Jean Fraser - Planner  
City of Portland  
Planning & Urban Development Department  
389 Congress Street  
Portland, ME 04101

October 16, 2013

Subject:       Munjoy Heights  
                  Preliminary Level III Site Plan Application  
                  Comment Response Letter

- Woodard & Curran – Peer Review Memo, dated October 9<sup>th</sup>, 2013.

UNDERDRAINED SUB-SURFACE SAND FILTER
TYPICAL CROSS SECTION
NOT TO SCALE

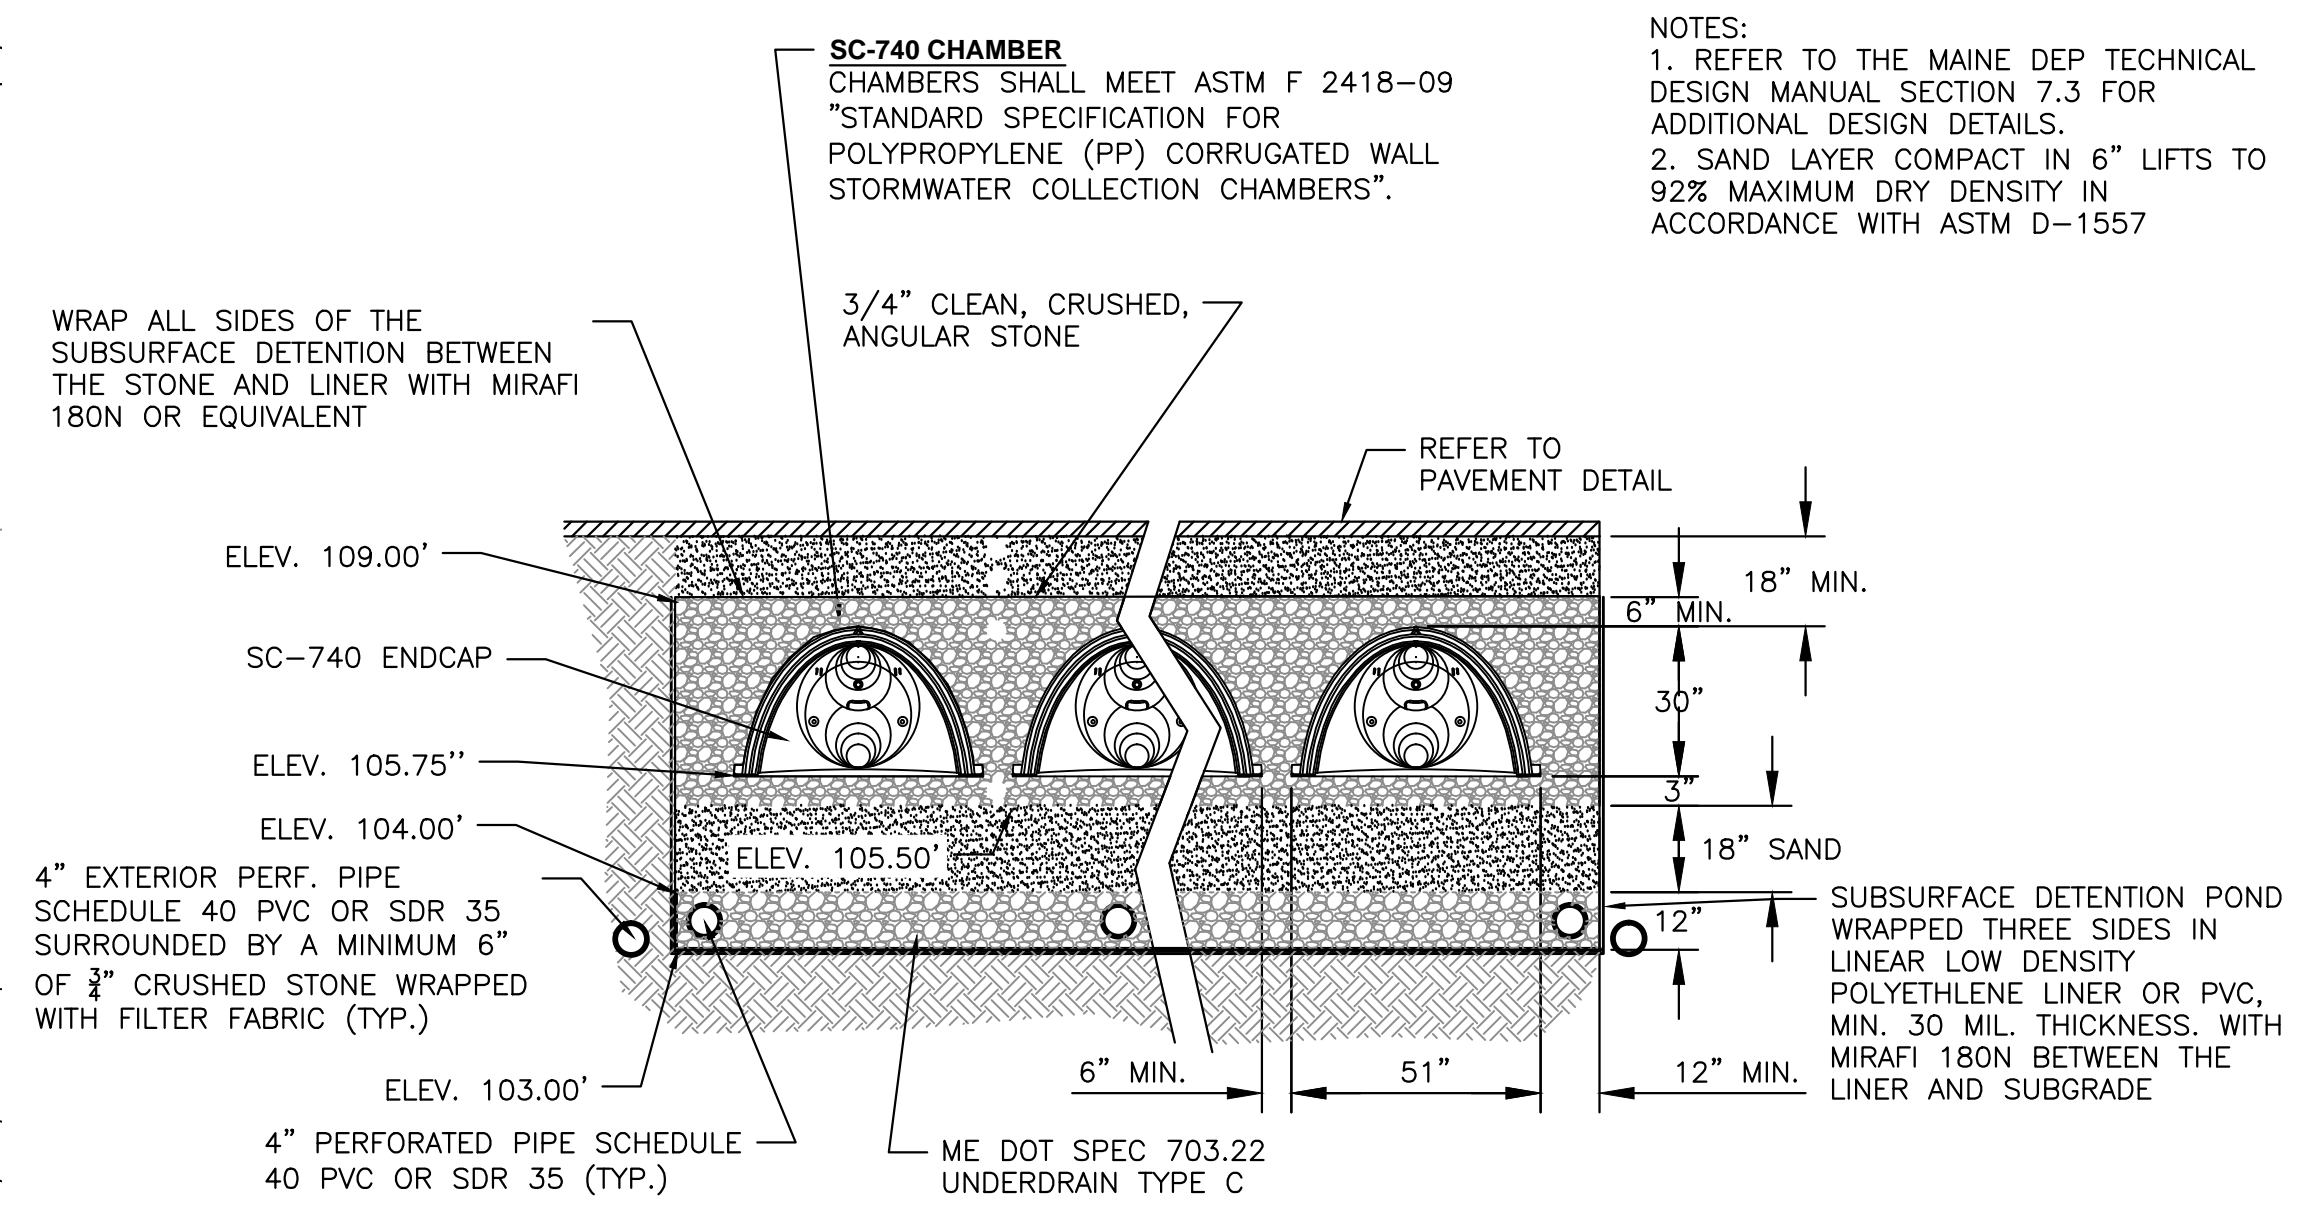
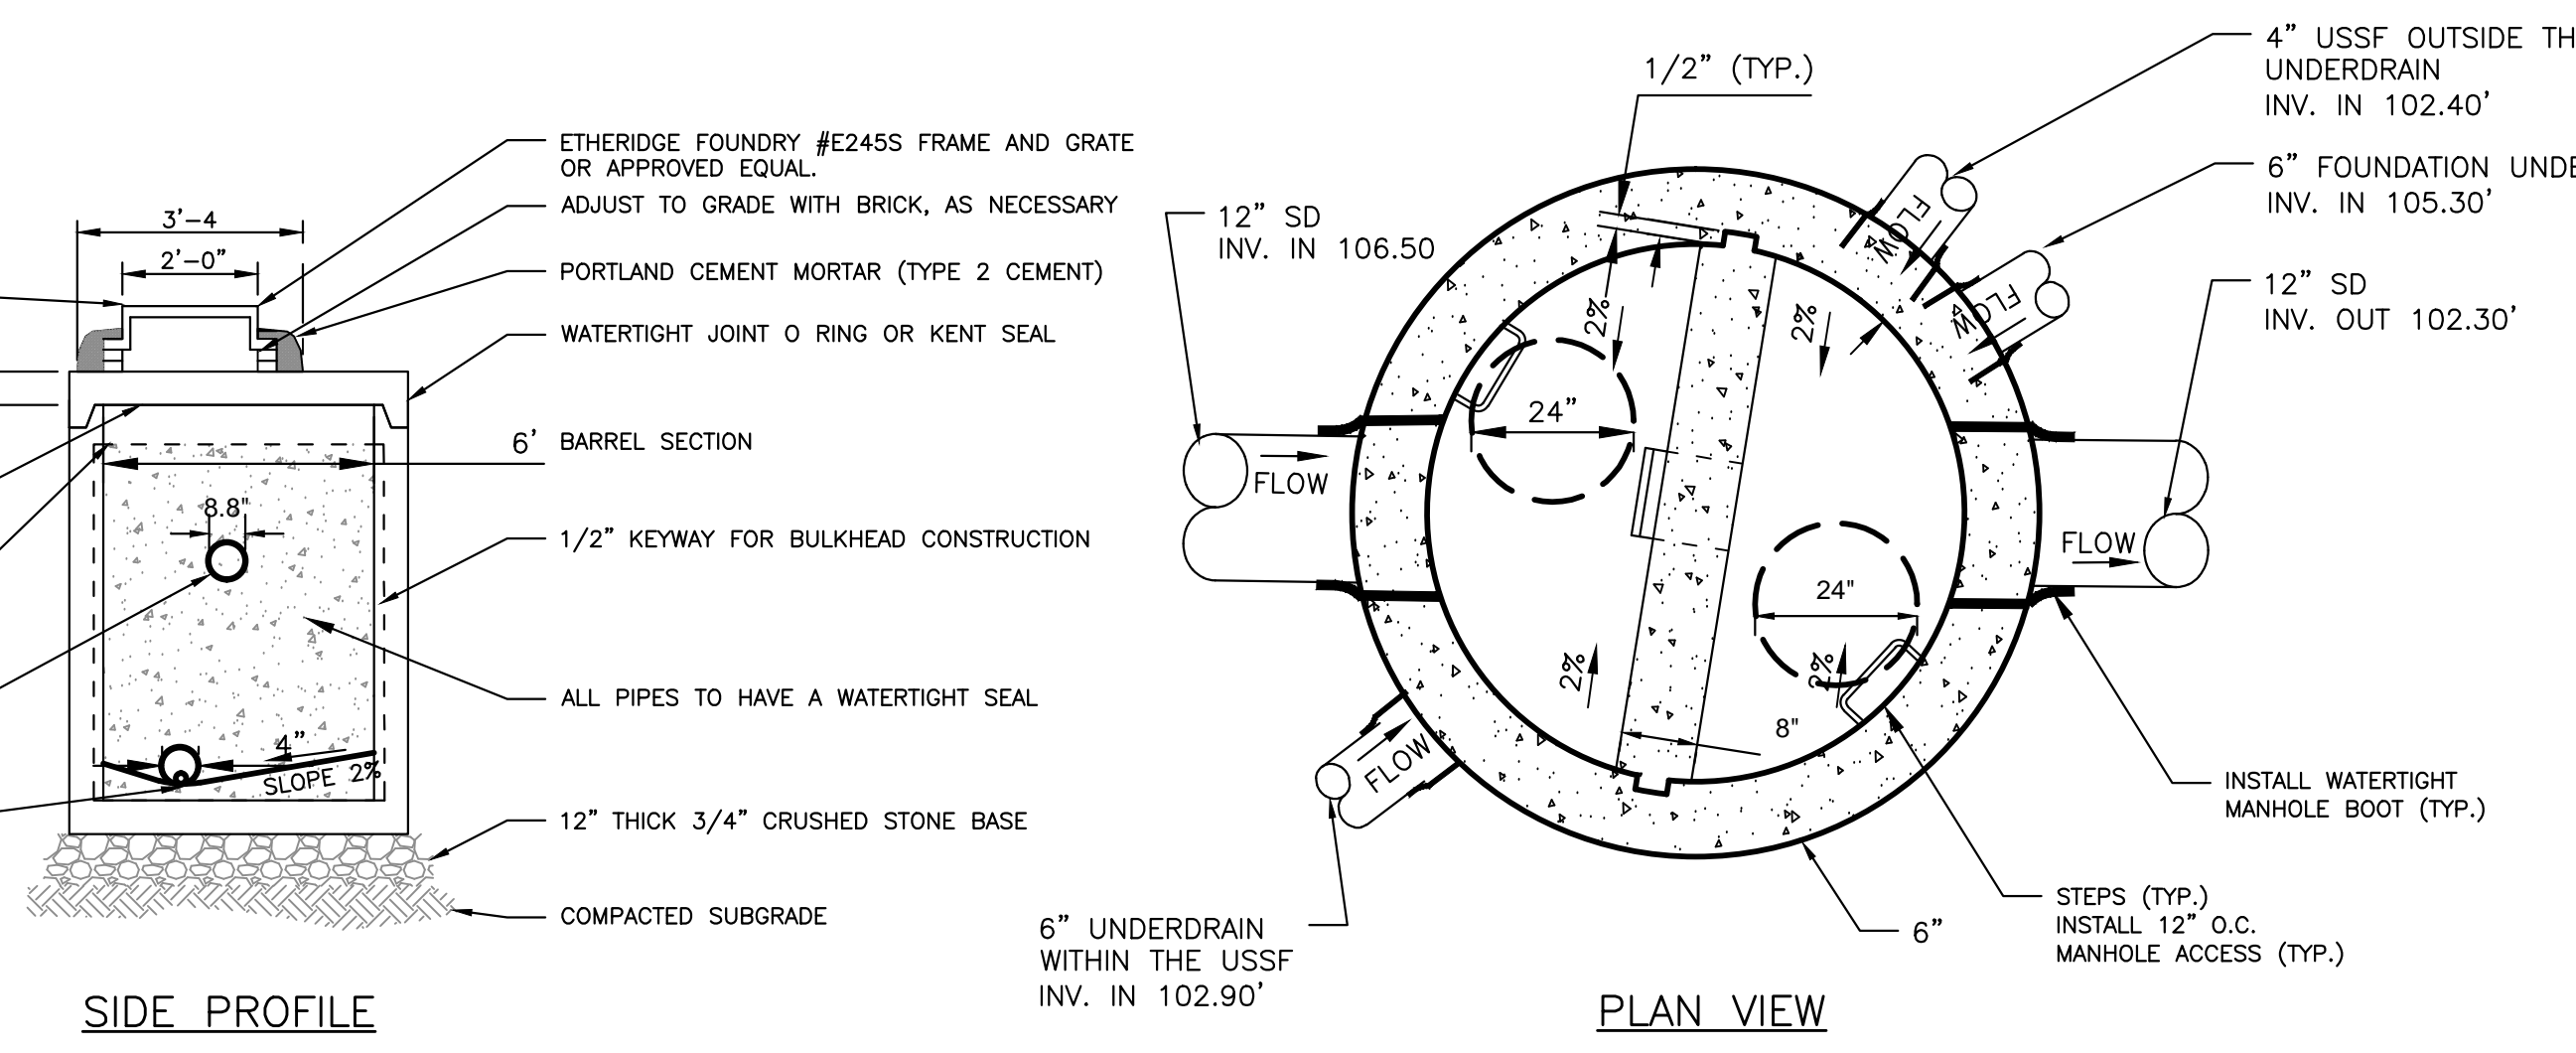
- b. *General Standards: The project will result in a net increase in impervious area of approximately 32,879 square feet. As such, the project is required to provide stormwater management features for stormwater quality treatment. The Applicant has noted that the intent is to provide an Underdrained Subsurface Sand Filter BMP to provide treatment for no less than 95% of the new*

*impervious area, and 80% of the developed area. We anticipated that additional notes, details and calculations will be provided to allow us to review the design of this system. In addition, the subsurface stormwater management system is proposed on a steep fill slope; as such, the geotechnical engineer should provide a review of the system design relative to potential impacts on slope stability, foundation drainage, and potential for break-out of infiltrated stormwater on the downhill side of the system.*

**Response:** As part of the Final Application the applicant will document that project meets the Maine DEP Basic, General and Flooding Standard. Furthermore, the geotechnical engineer will review the impacts of the proposed stormwater infrastructure.

**CROSS SECTION
STA 301+30.00**
SCALE: 1" = 20'

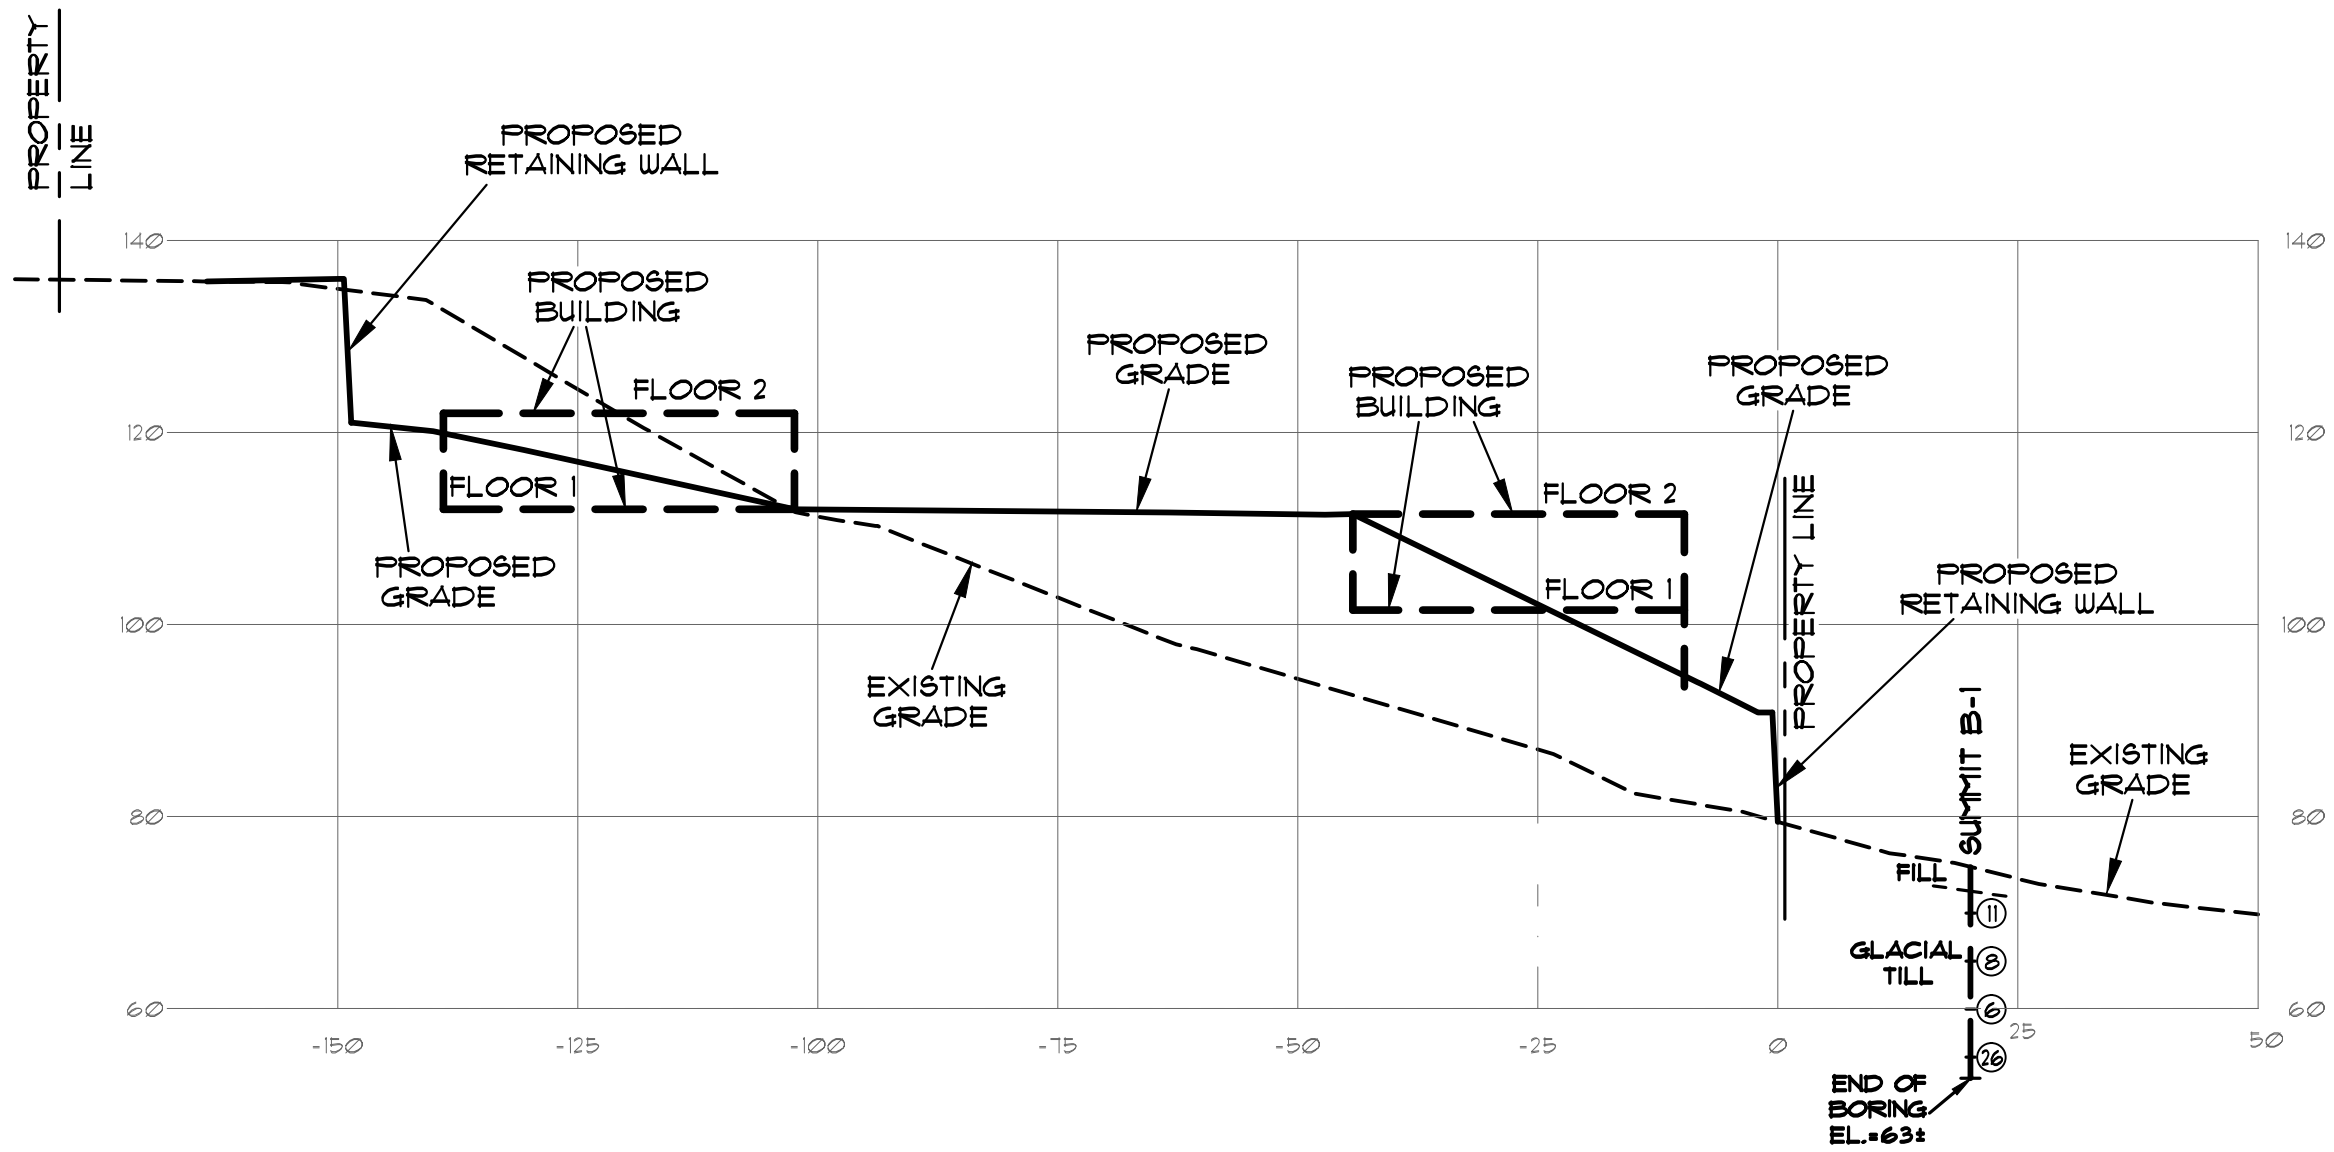
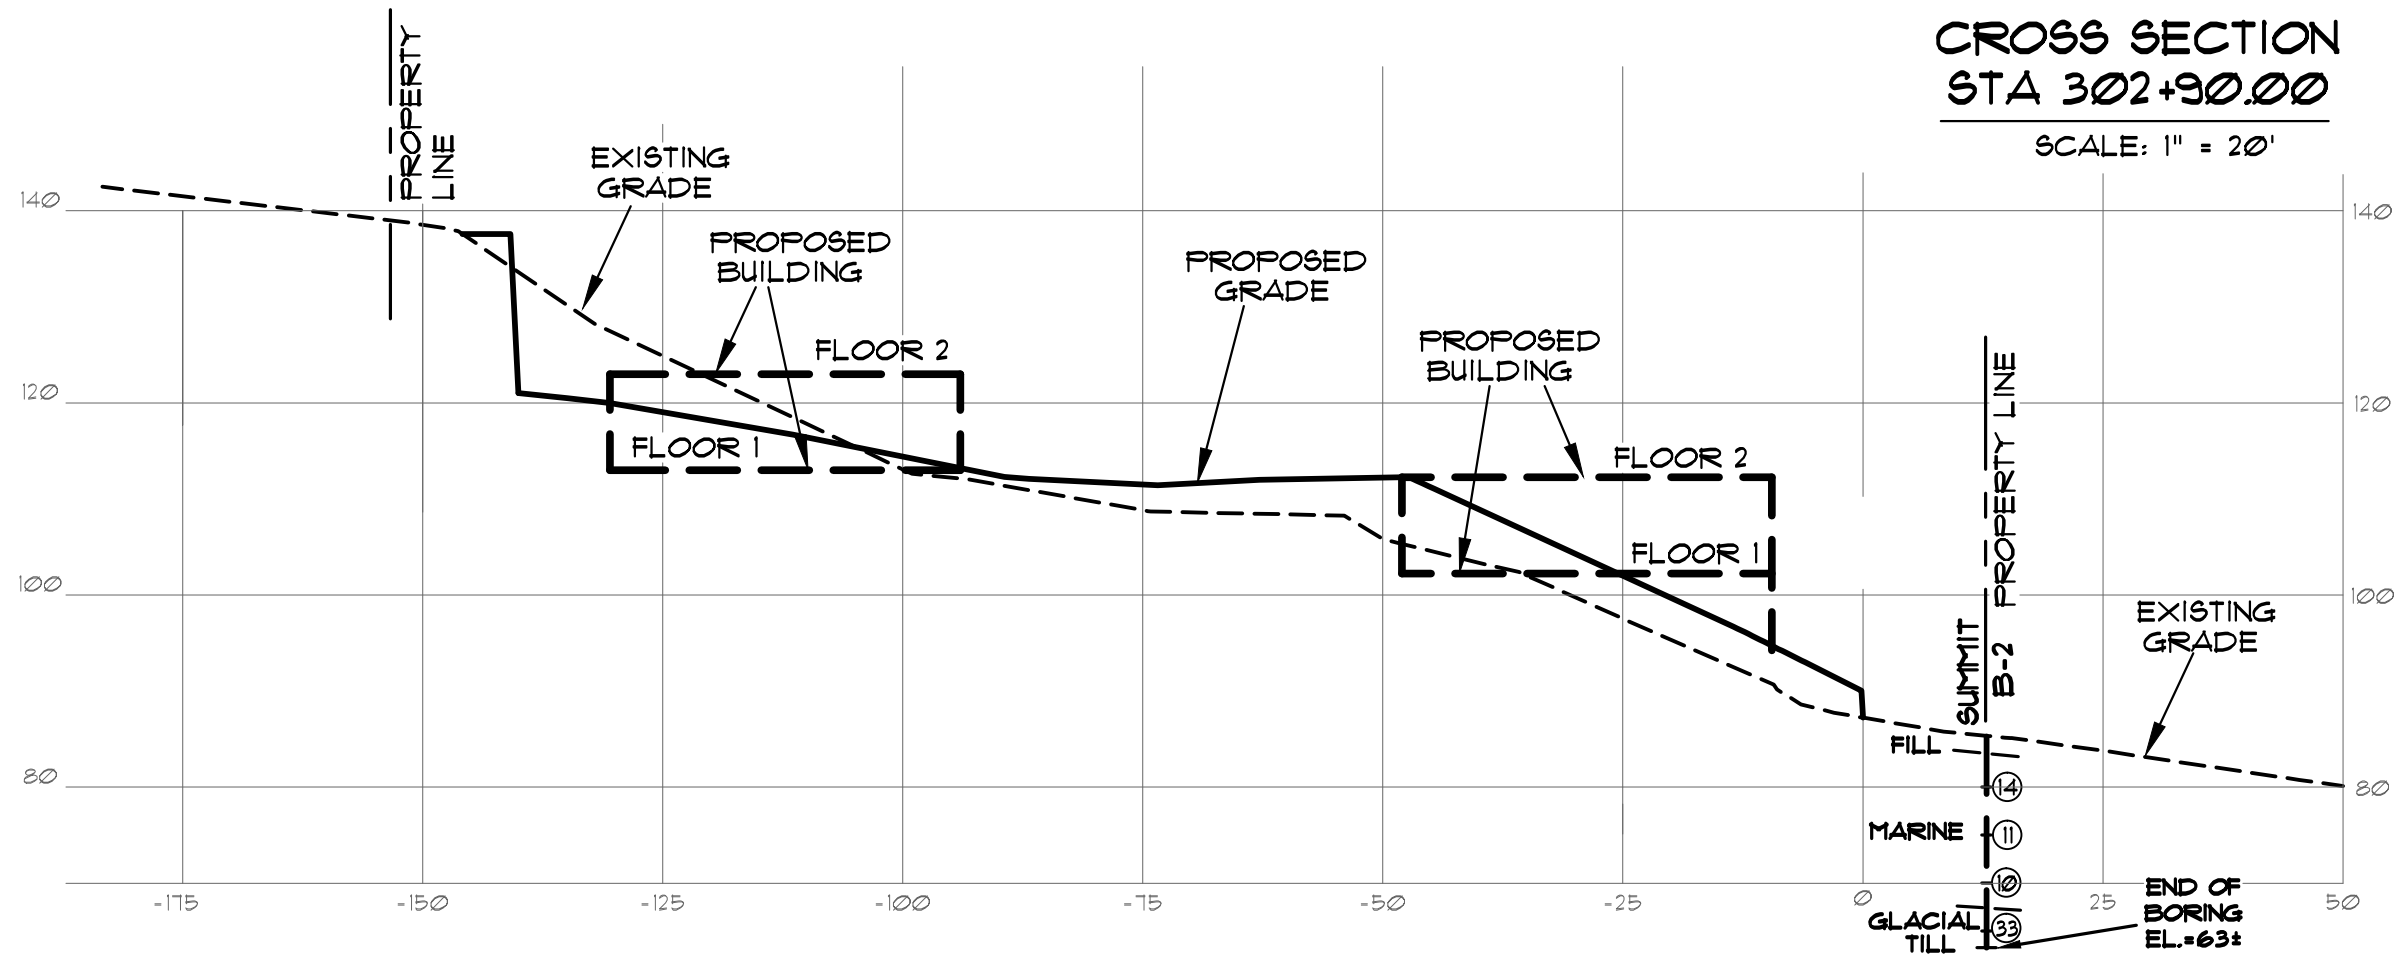
- 7) *The Preliminary Geotechnical Report has noted that the proposed grading at the site will require the construction of retaining walls near both the east and west property*

*lines, and that the walls are estimated to be up to 25-feet high. The final submission should include specific details for these proposed walls, in addition to any associated assumptions and geotechnical design criteria.*

**Response:** The following response is from Bill Peterlien, P.E. President & Principal Engineer of Summit Geoengineering Services, Inc. in an email October 15<sup>th</sup>, 2013. The Typical Wall Cross-Section Detail is attached to this letter.

“A typical retaining wall cross section is attached. Summit Geoengineering Services, the geotechnical engineer of record for this project, has been retained to design the retaining walls. SGS will consider the following conditions in the wall design.

1. Internal and external wall stability for all walls.
2. Global Stability for the east walls (fill side).
3. Method of constructing the west retaining walls - open cut and temporary or permanent shoring.
4. Consideration of the new building foundations in the design of the east walls.

A set of wall construction drawings stamped by a Maine PE will be prepared prior to construction. We anticipate submitting the wall drawings along with other documents submitted to obtain a building permit for the project.”
